Player Wills

Stage 1 Road Safety Audit

Client:	Systra
Project Title:	Player Wills
Document Title:	Stage 1 Road Safety Audit
File Name:	200929-20640-RP-0002_Stage_1_Road_Safety_Audit_P01

Title: EXTERNAL JUNCTIONS

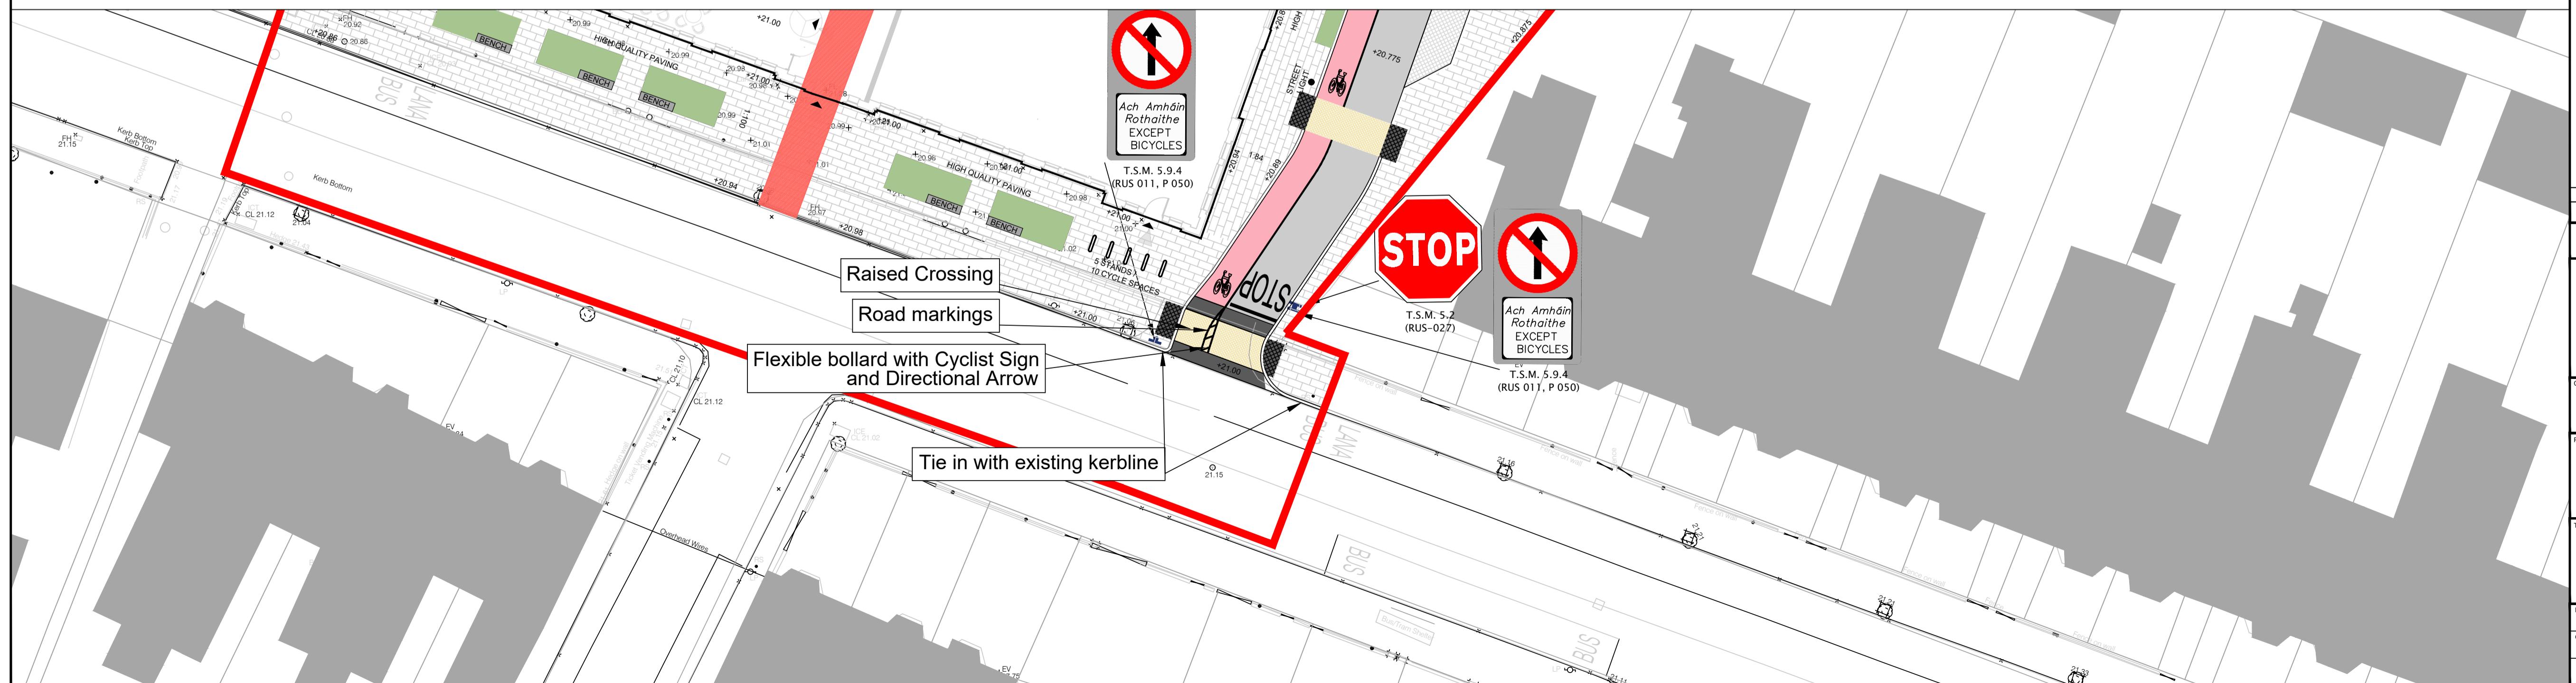
Review orientation of the stop line centreline to ensure it follows the centreline of the proposed access.

2.9	Yes	Yes	Wayfinding to be provided as part of the Detailed Design Stage	n/a
2.10	Yes	Yes	This issue has been resolved as shown in the Planning Drawings	n/a
2.11	Yes	No	Due to the low speed and volumes on this road, we are proposing that cyclists will share the road space as throughout the site when travelling southbound, therefore there is no need to provide a 2-way cycleway (2.5m wide). The potential narrowing of the traffic lane to 3m wide will be investigated at the Detailed Design Stage	Yes
2.12	Yes	Yes	Signage arrangement at the entrance of the development to be provided as part of the Detailed Design Stage	n/a

The signage arrangements at the entrance to the development are not presented in the information received. Provision should be made for clear signage to ensure that drivers do not get confused when looking to access the development, leading to the possibility of coming into conflict with other road users.
